Letter No.C

2/799/2004

Sub: CMDA - Planning permission Proposed

Proposed additional construction of Factory building at Plot No.4&5 Developer Plots Estate in S.No.12/8,11 of Seevaram Village Development Charges and other charges to be remitted - regarding.

SITE CUM STILT GROUND FLOOR PLAN
SCALE: 1:200

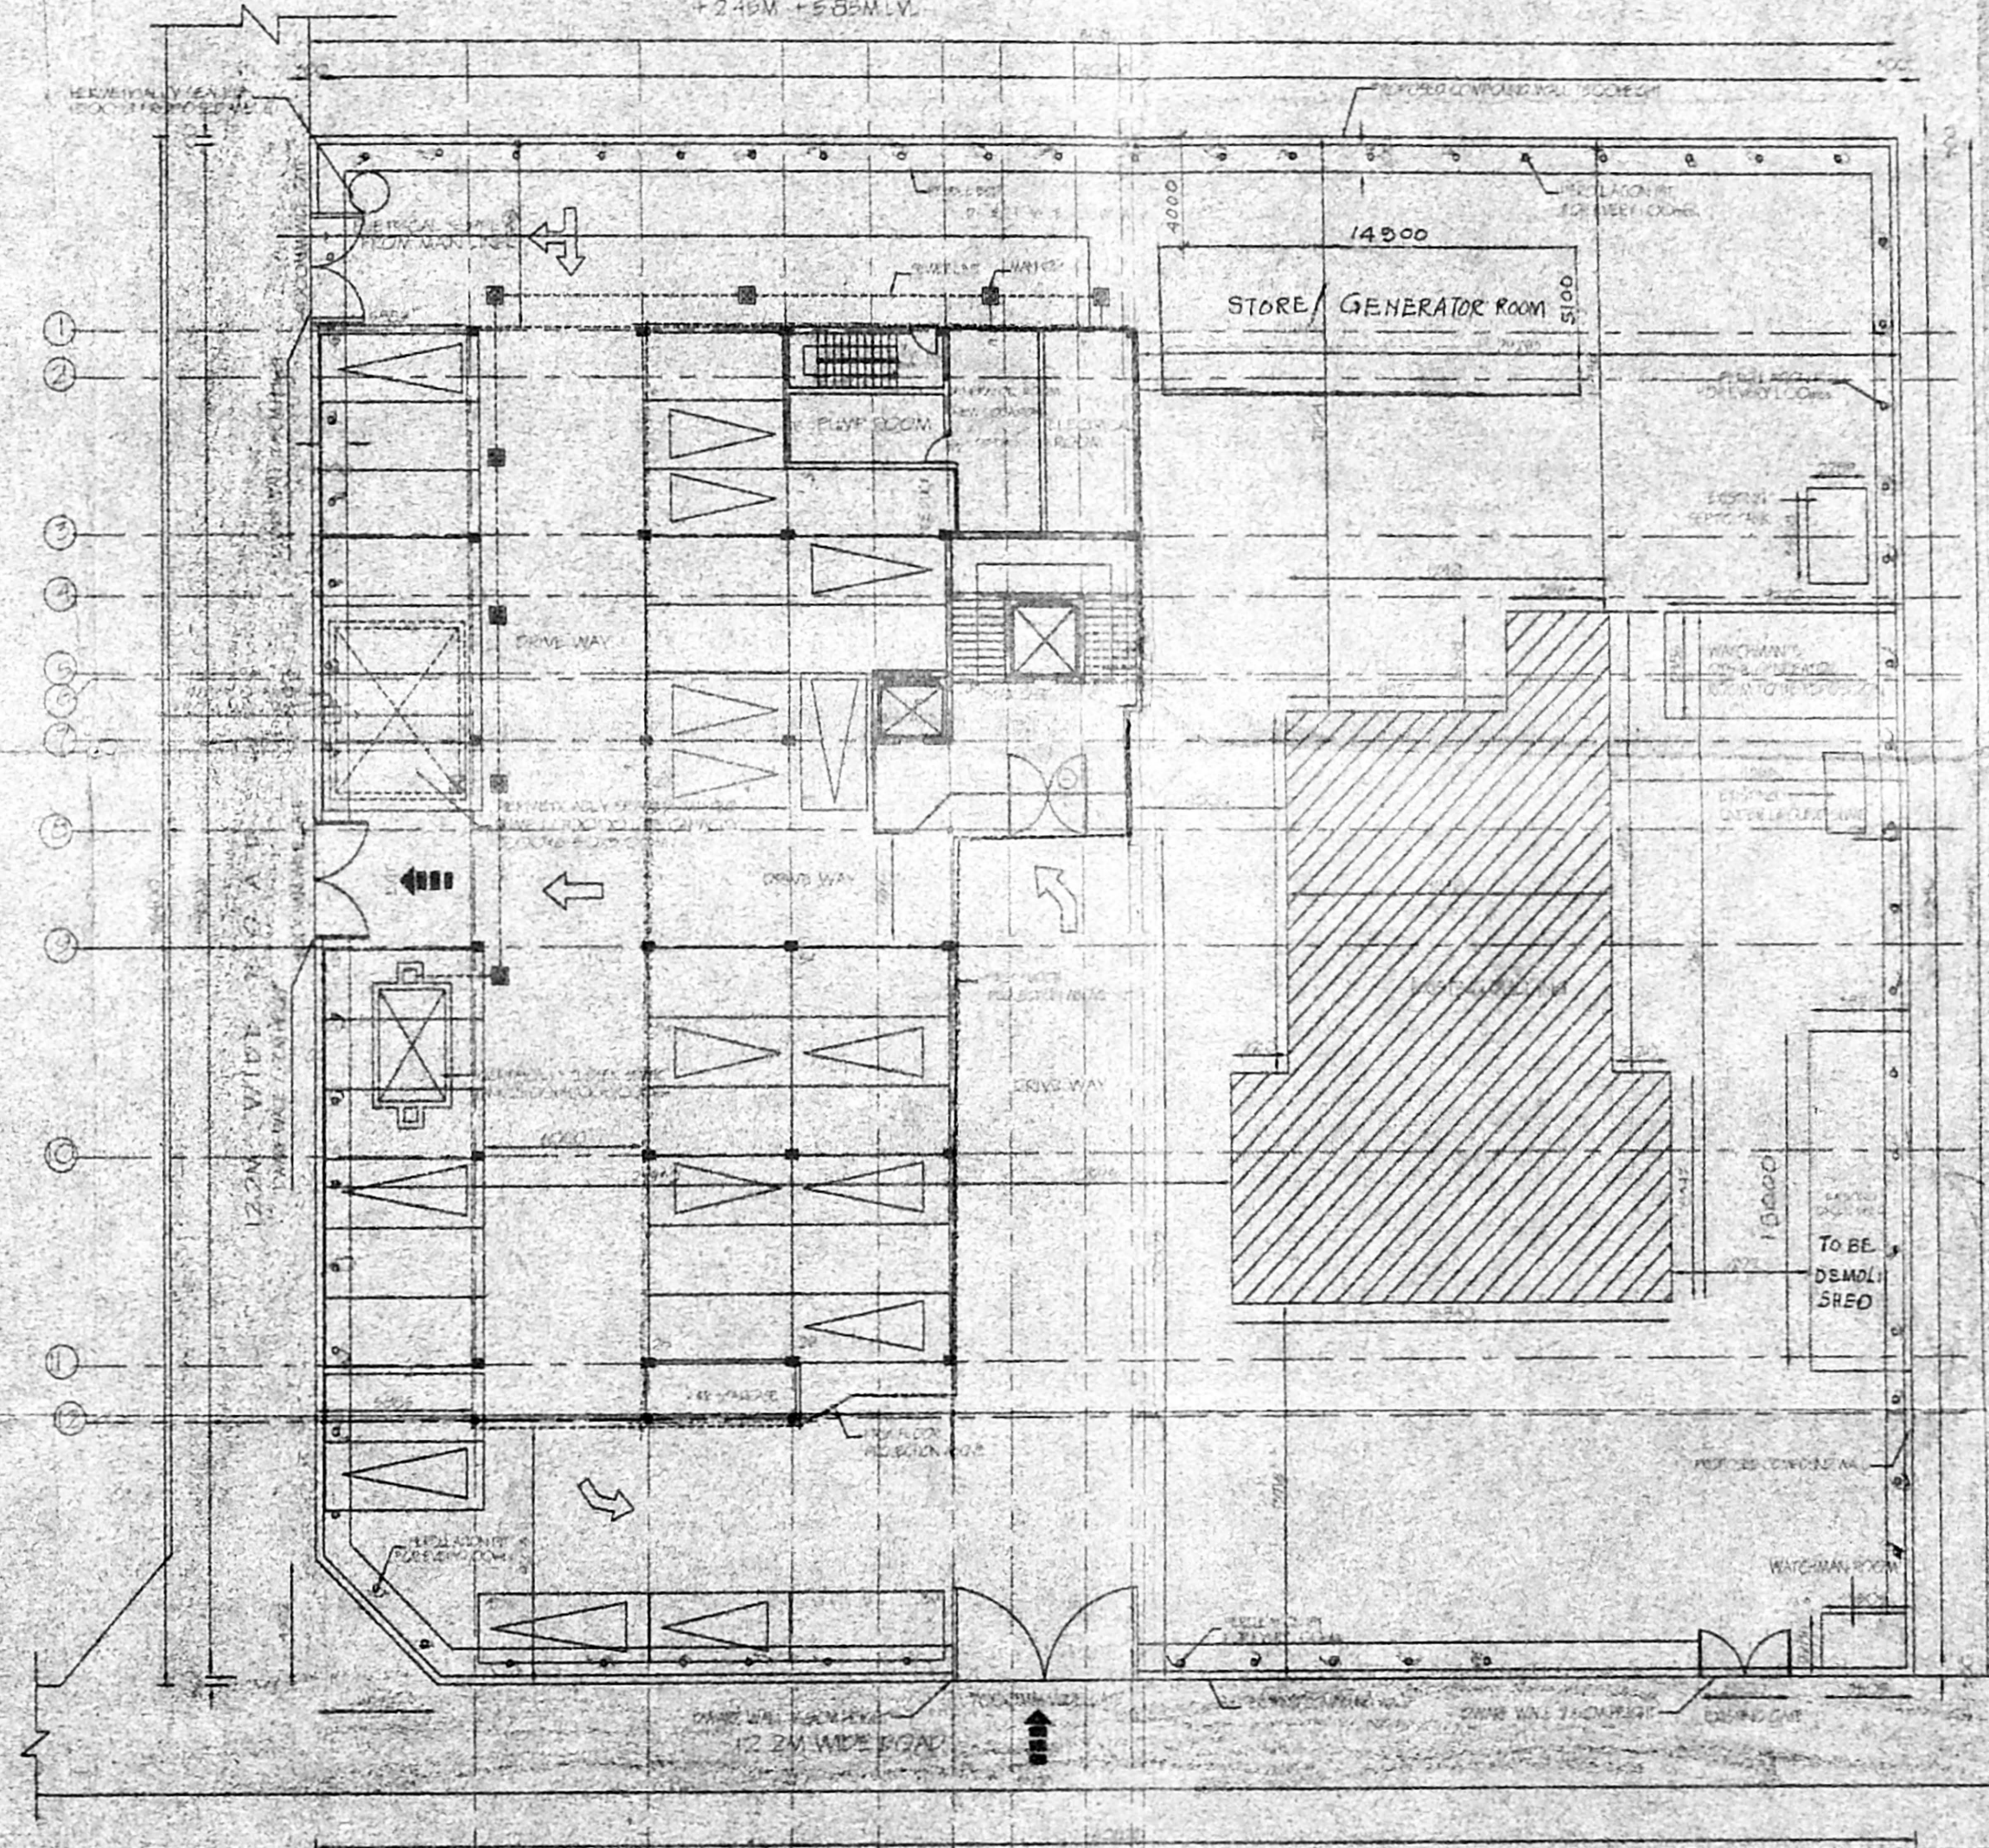
- a) Rain water conservation measures notified by CMDA should be adhered to strictly.
- b) **Valid Tamil Nadu Pollution Control Board consent letter.**
- c) **Revised site plan incorporating the words "to be demolished" at the existing cycle shed and show the Generator Room.**
